DECISION DELEGATED TO HEAD OF PLANNING

Application No:	H22-0336-25	Applicant:	Mr P Coleman
Proposal:	Single Storey Rear Extension to Form Dining Room & Internal Alterations		
Location:	Oakleigh House 3 Pinfold Lane Weston		
Terminal Date:	15th August 2025

Drawing Title:
**Plans, sections and elevations as
proposed**

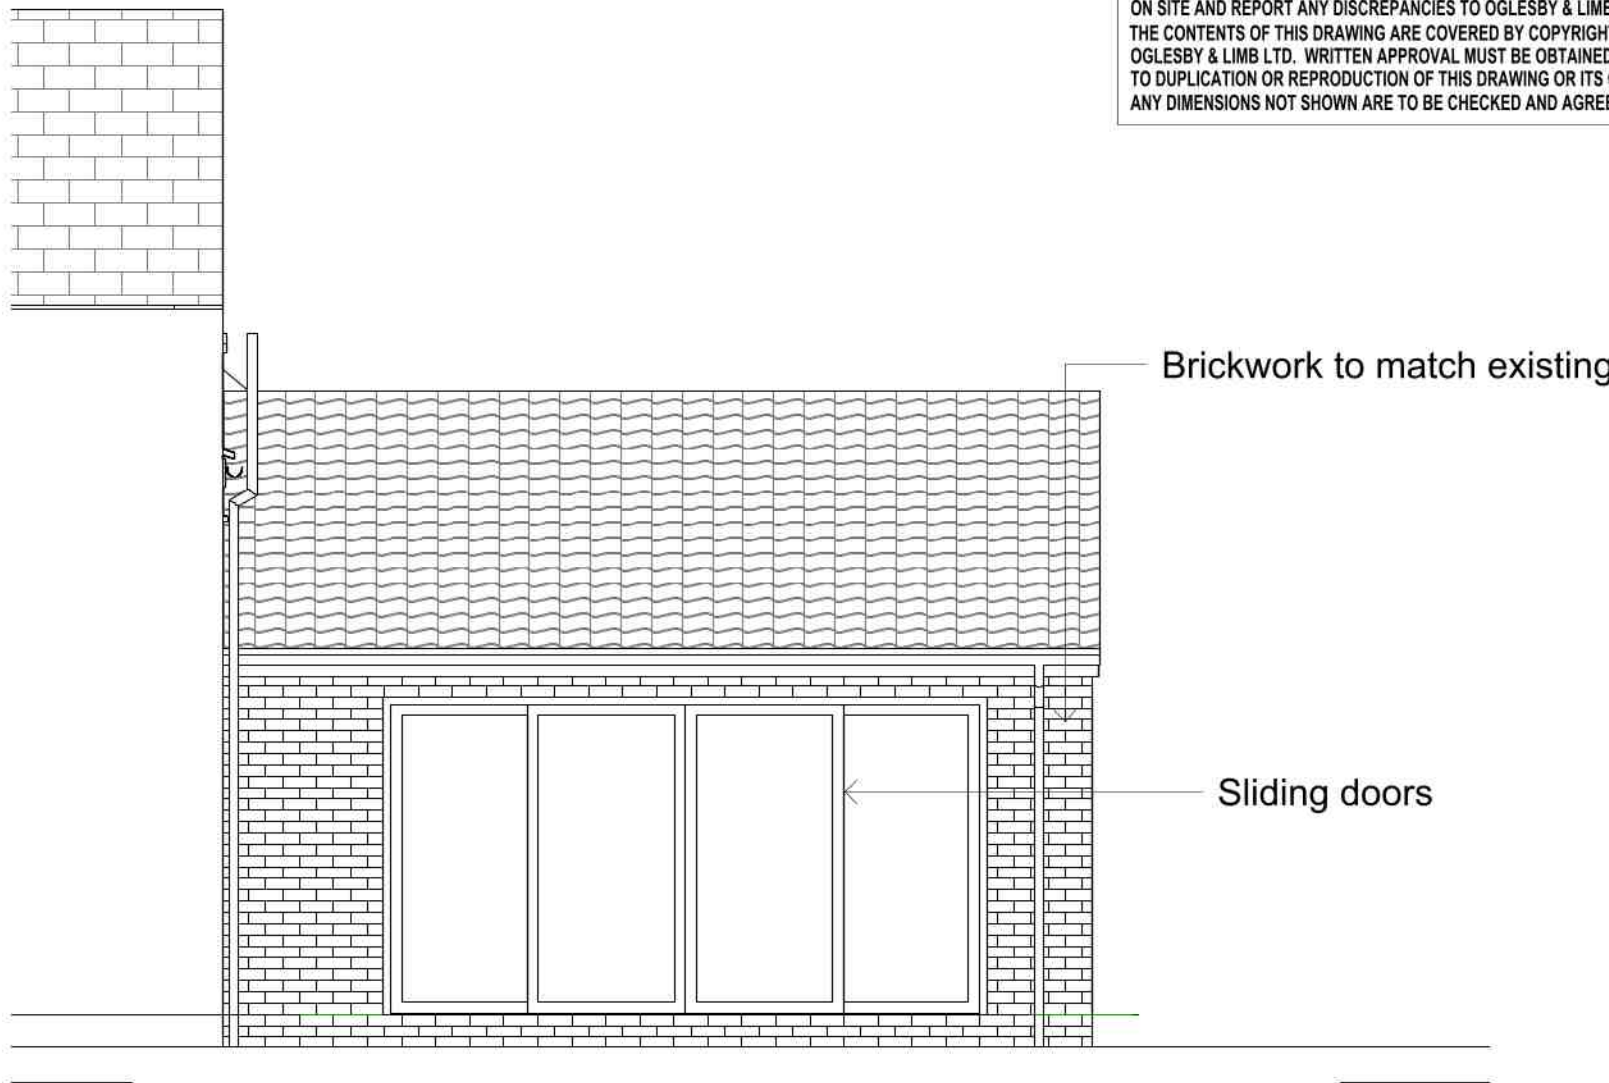
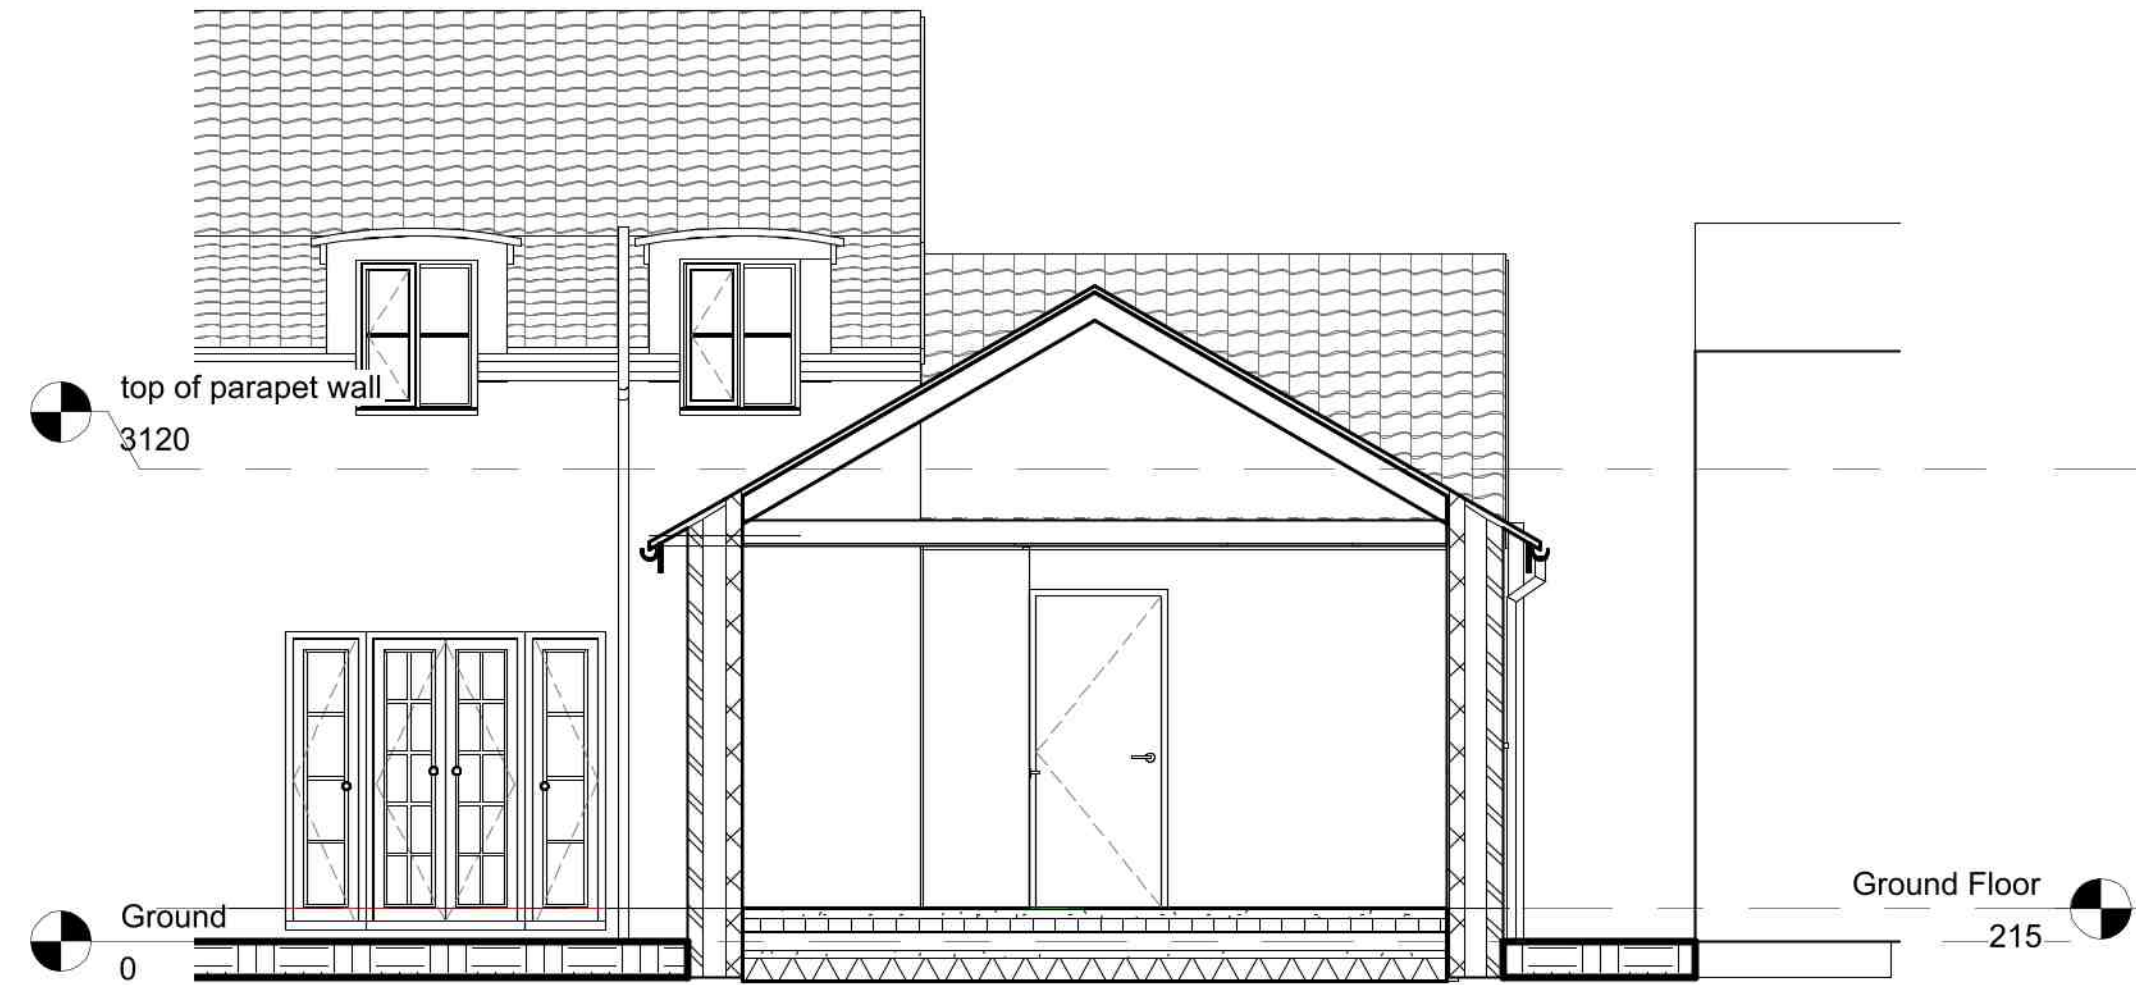
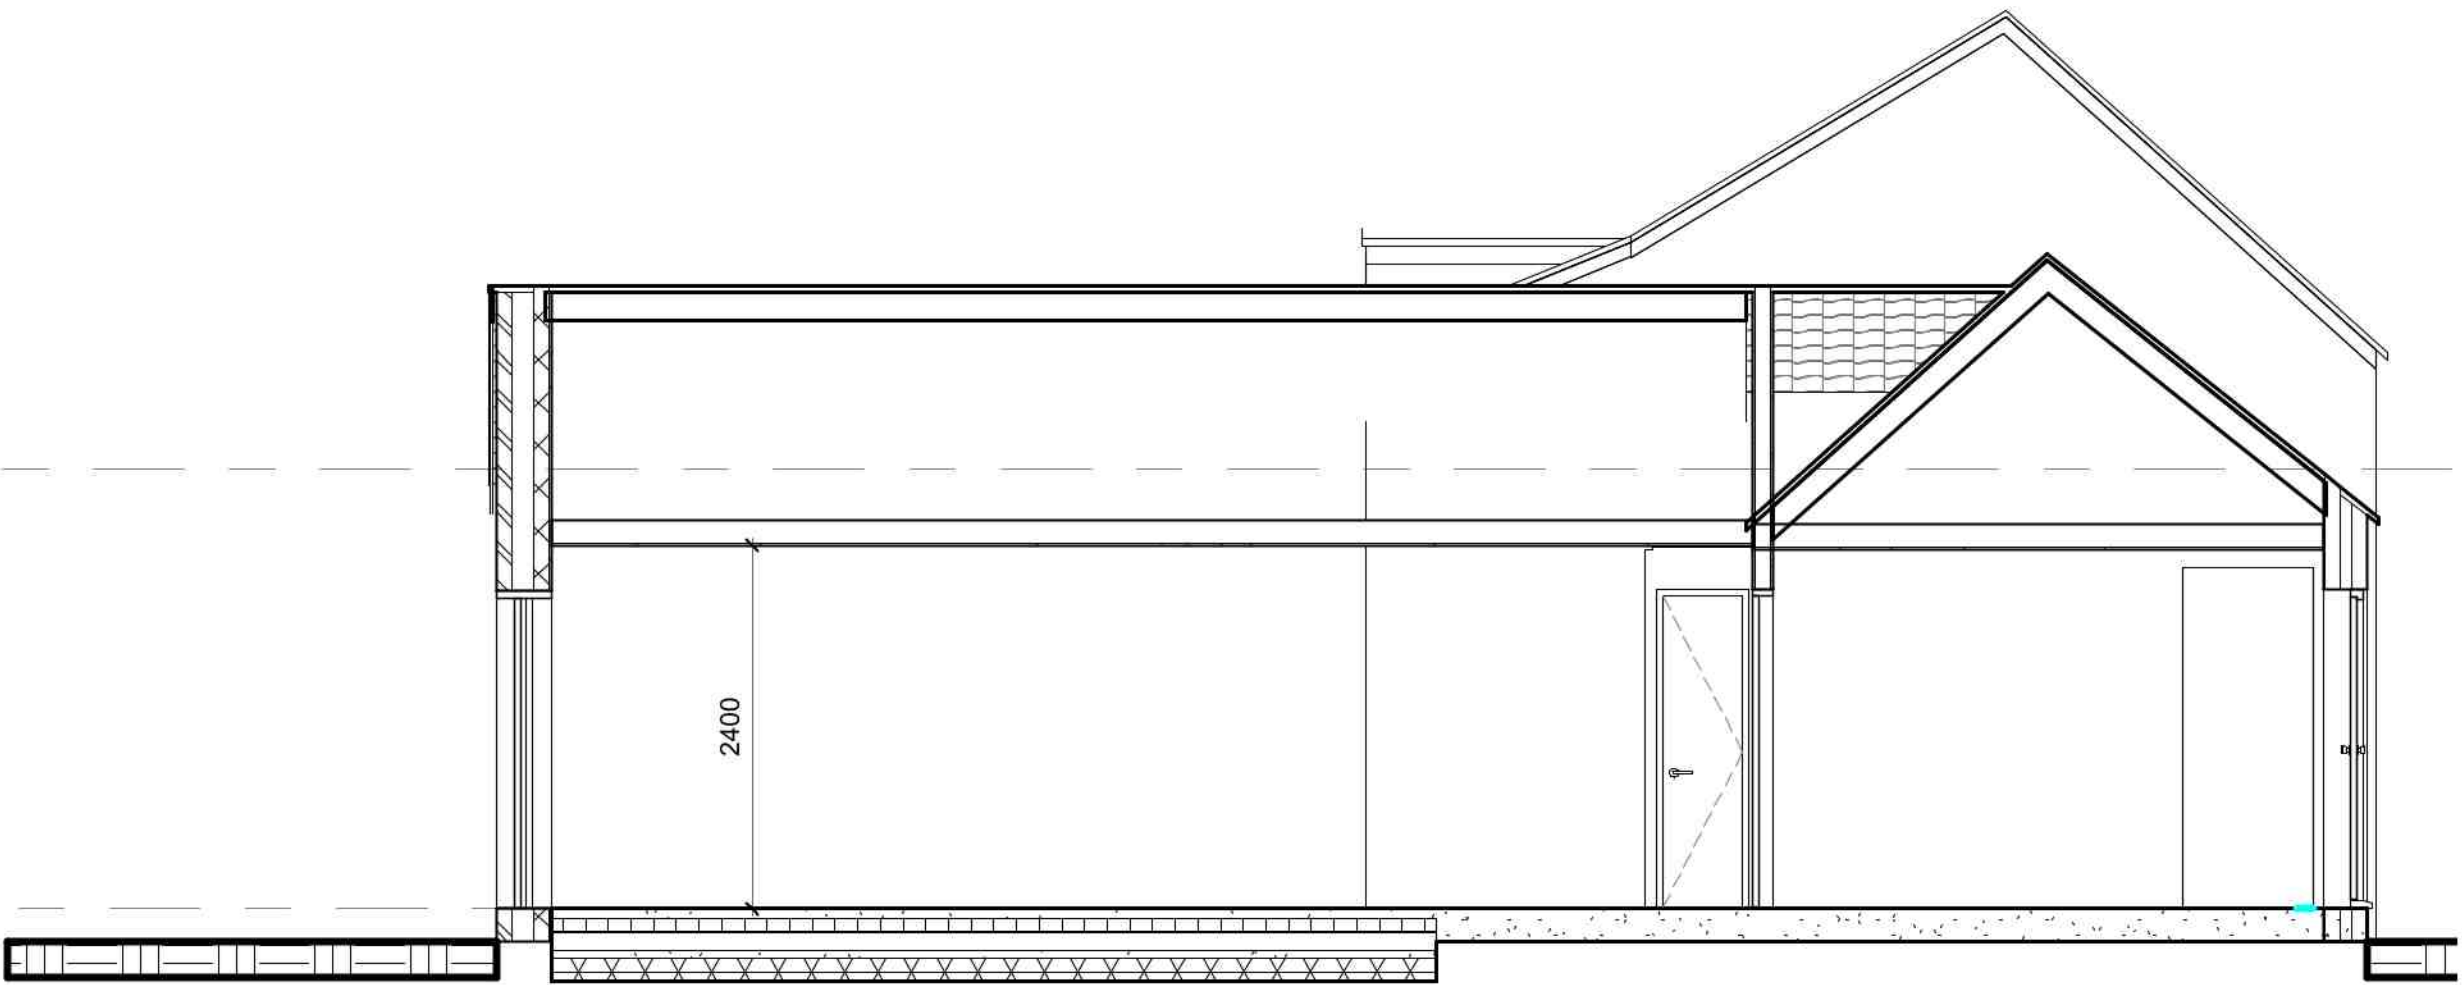
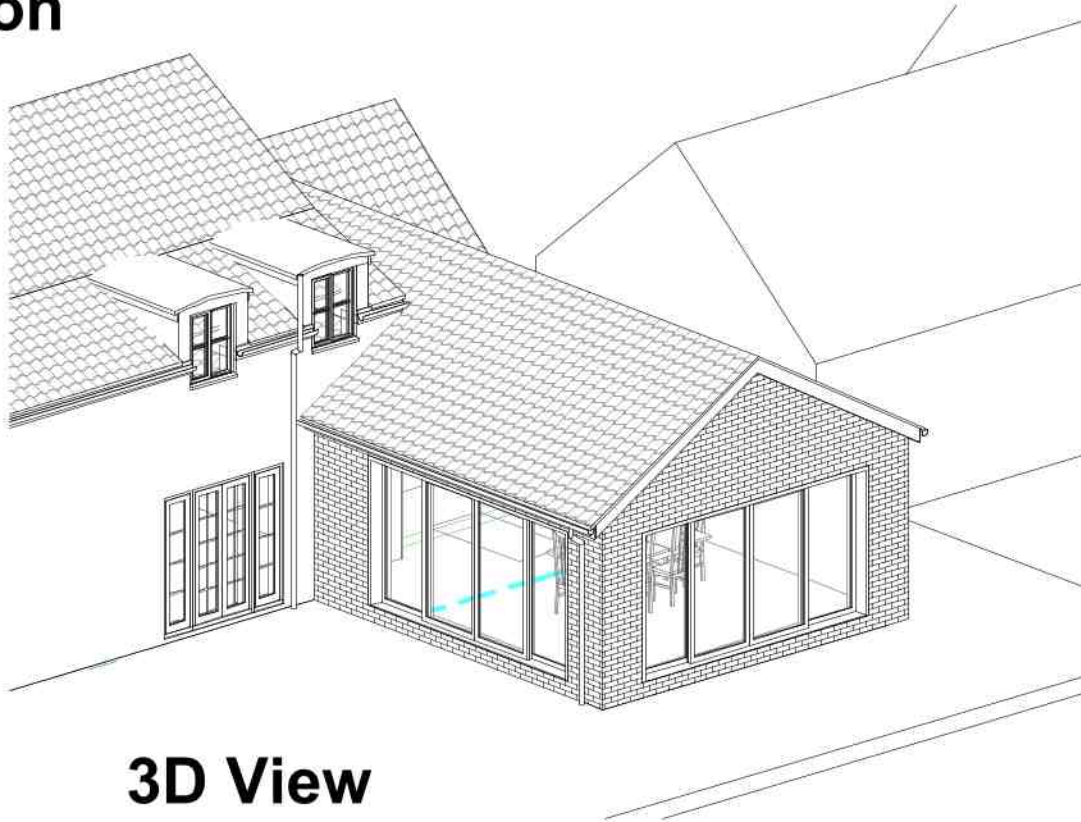
The applicant has provided an amended scheme, and the extension now consists of a single storey dual pitched roof structure with bi-folding doors on two elevations, opening into the garden, with the other elevation blank. Materials are annotated on plan and the structure is to be finished in a matching facing brick and pantile.

I write to confirm the removal of objections to this proposal. The new roof arrangement should give the impression of a more authentic addition to a range of secondary structures to the rear of an original listed property, rather than the originally rather awkwardly-grafted on modern facsimile appearance of the original proposal. Whilst this is by no means the most outstanding example, this is a compromise settlement that is more satisfactory, and should not detract from the character of the important frontage range building by appearing to be an out of keeping addition to this - admittedly lower in the significance hierarchy - later addition of rear range buildings. However, the success of this proposal will be pivotal upon the fine detail and materials of construction. I therefore suggest the imposition of conditions requiring details of all materials of construction, including a brick sample panel and of all proposed fenestration, doors and also of all domestic accoutrements including rainwater goods. The applicant has indicated in their application form that the rainwater goods would be UPVC - this is unacceptable, and all such goods should be black metal at least - however, this can be settled via a condition instead of further amendment.

The applicant seeks to erect a single storey rear/side extension, which would function as an extension to form a kitchen/dining room. The proposal is for a brick built, dual pitched extension. The plans show that on its short side, the southwestern elevation the extension would measure approximately 5.75m and on its longer side approximately 6.7m, the ridge would sit lower than the existing utility room to which it would attach. The proposal would contain sliding doors on both the northeast elevation and south west. The other elevation (northwest) would be facing brick with no punctuation.

Materials are stated on plan to match existing; this includes both roof dressing as well as facing brick.

NPPF Paragraph 208 requires that LPAs should assess the particular significance of any heritage asset that may be affected by a proposal; the location of the extension, to the side rear, as confirmed by the conservation officer, would extend from a less important/significant part of the listed building and therefore this avoids/minimises the conflict between the heritage asset's conservation and the proposed development. It would also be screened from the street somewhat by the existing conservatory. By virtue of the notion that the extension would not overly impact the listed buildings most significant elements (thus not resulting in conflict between the heritage assets conservation and the kitchen extension), that it is screened from the street and that its scale and massing, whilst large is still subservient to the dwelling then the proposal is considered acceptable in this instance.

Therefore, in line with the conservation officers comments the proposal, is considered acceptable subject to control over materials, including opening and rainwater goods which shall be submitted to and agreed in writing with the local planning authority prior to any above ground works.
